Charlotte Department of Transportation

Memorandum

Subject: Rezoning Petition 08-035: Located on both sides of Statesville Avenue
between Woodward Avenue and Dearborn
Avenue

SP101

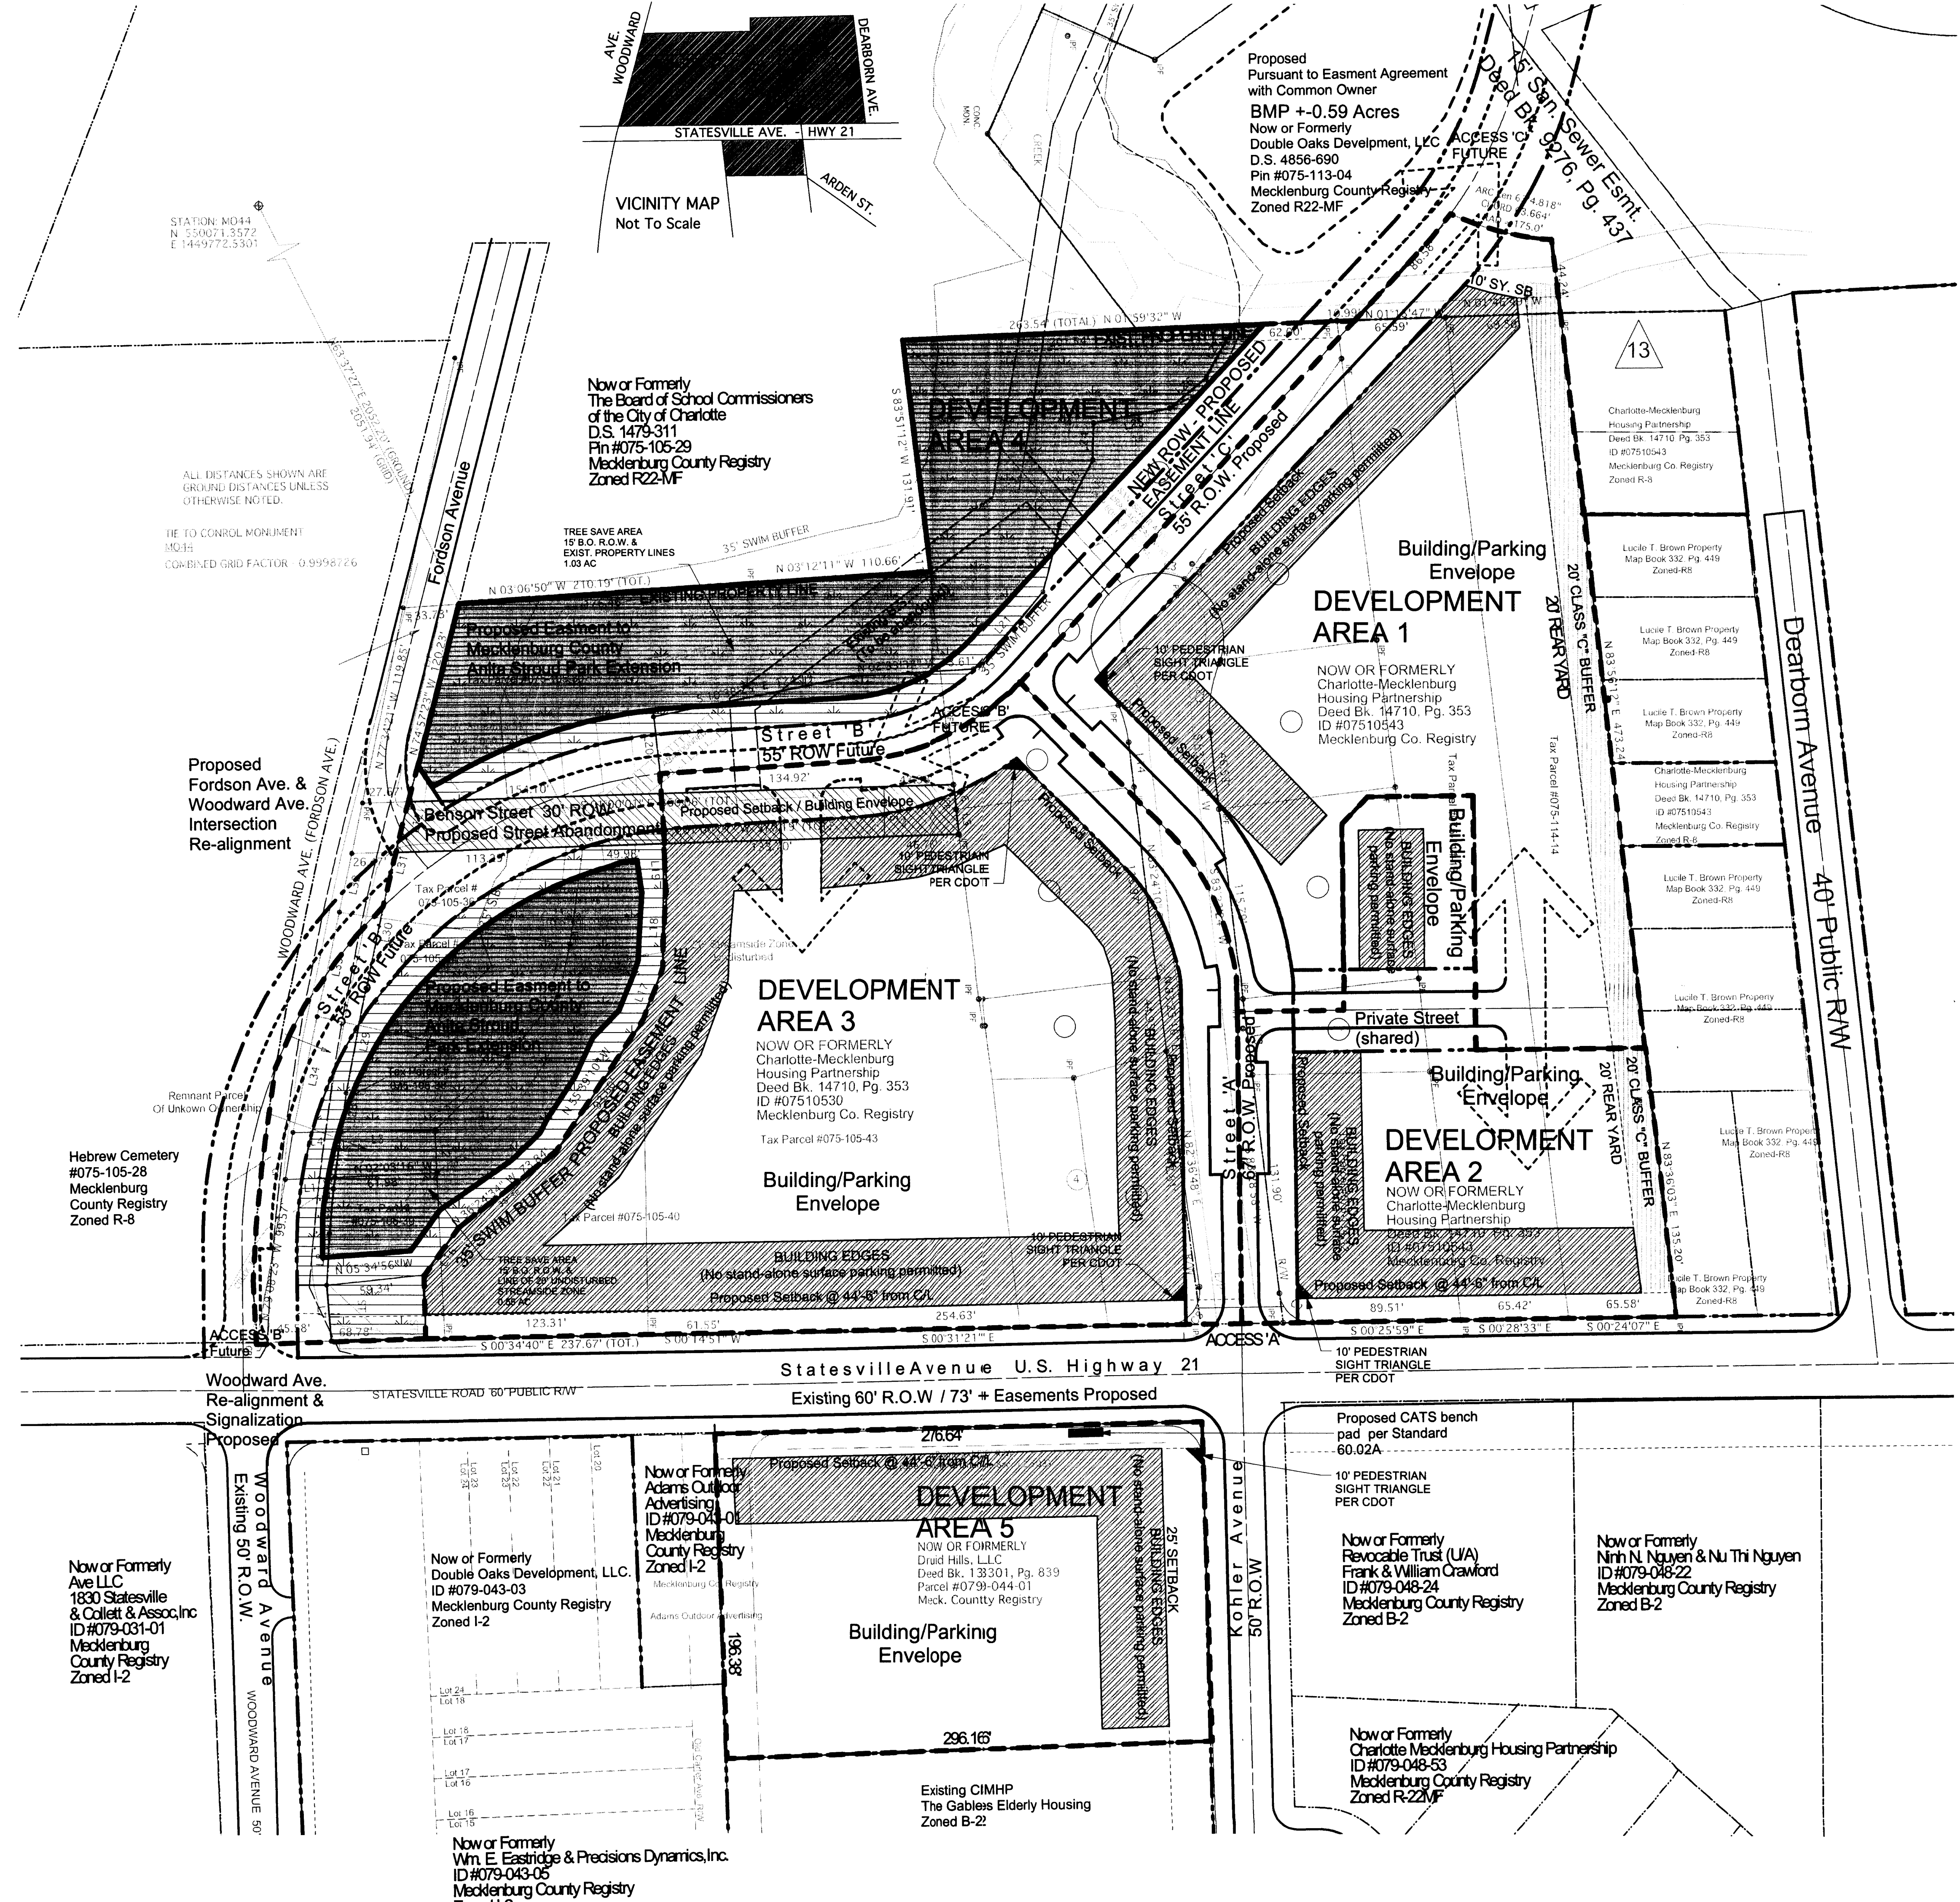
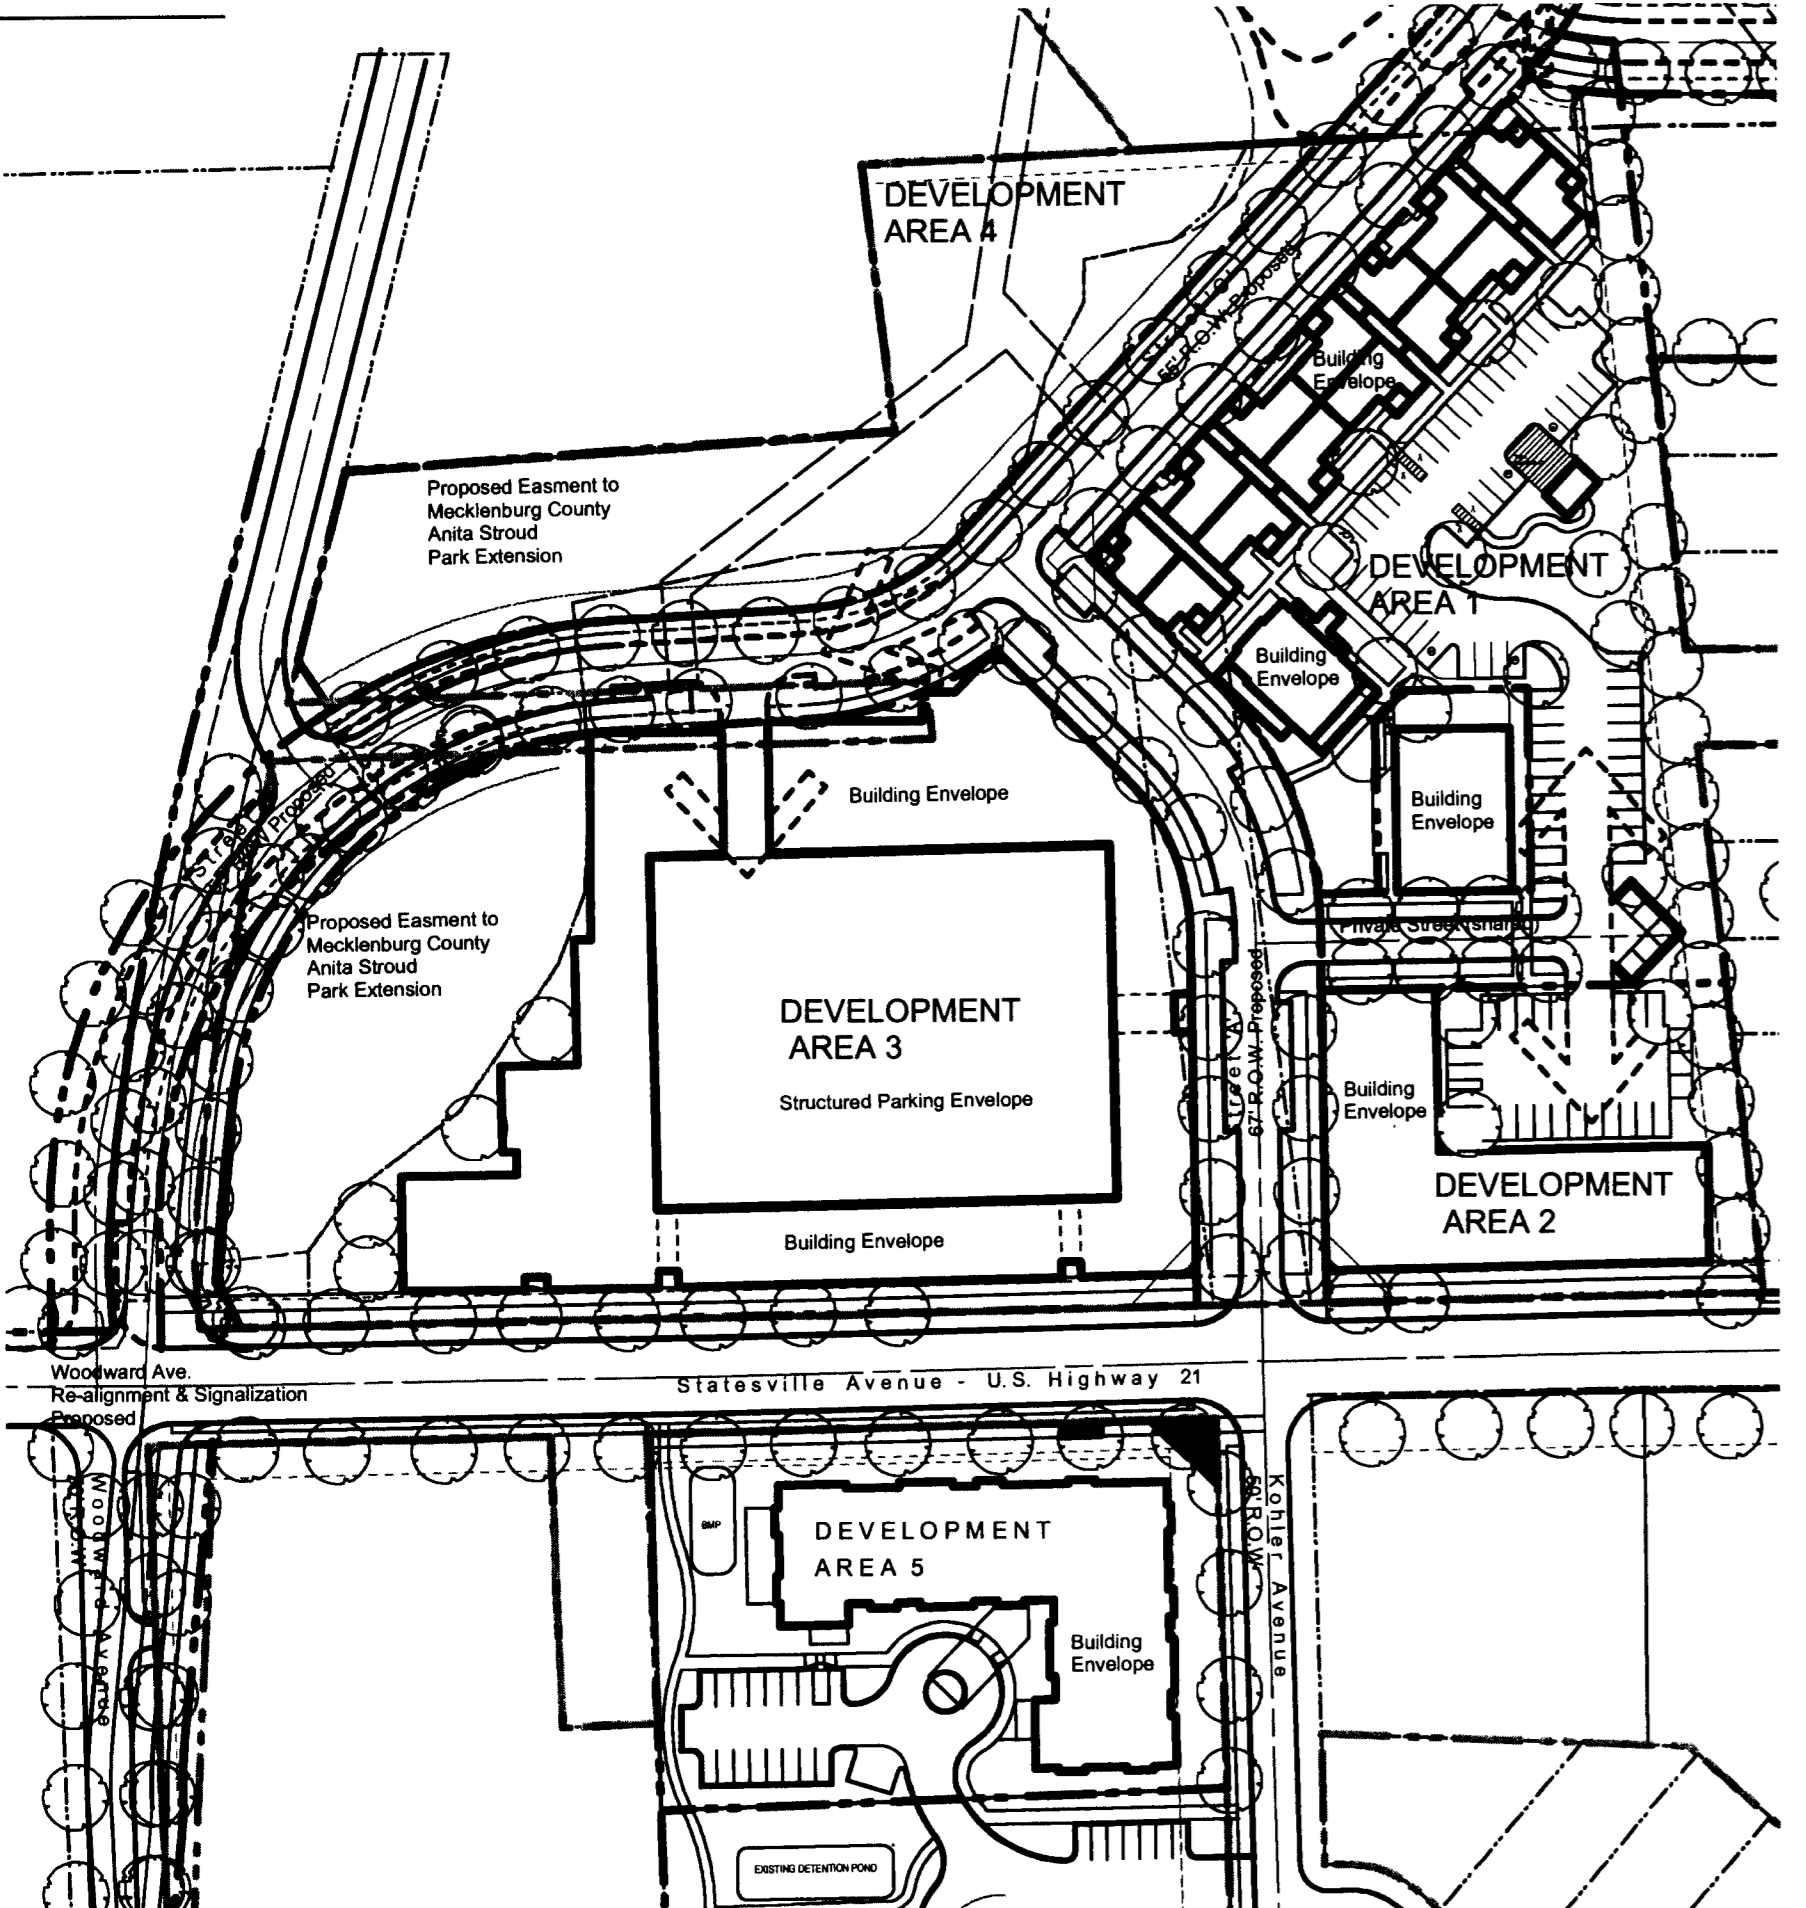
1. The site plan shows a proposed realignment of Fordson/Woodward Avenues to directly connect as the 4th leg of the existing Statesville/Woodward intersection. This proposed realignment and necessary improvements will be further reviewed by CDOT and the NCDOT during the review of the TIS.
2. The proposed realignment of Woodward Avenue is shown on an adjacent parcel (075-105-28). This property needs to be acquired before the realignment can be approved.

3. Development Area 1 on the plan shows a future connection to a future or existing street. This connection is too close to the intersection of proposed Woodward Avenue and this street and needs to be removed from the plan.

4. Many of the Development Areas do not indicate proposed access locations. All proposed access locations to existing and proposed public streets need to be shown on the site plan. Access will not be approved on Statesville Road to serve Development Areas 2, 3, and 5 and the un-numbered Development Area adjacent to Development Area 5. Access to these development areas must be provided by streets internal to the development.

5. The proposed realignment of Woodward Avenue directly affects the access to an adjacent elementary school. The petitioner needs to demonstrate that the realignment will not adversely affect stacking for student pick up at the school. The petitioner needs to have discussions with the school/CMS and accommodate the needs of the school with their roadway design.
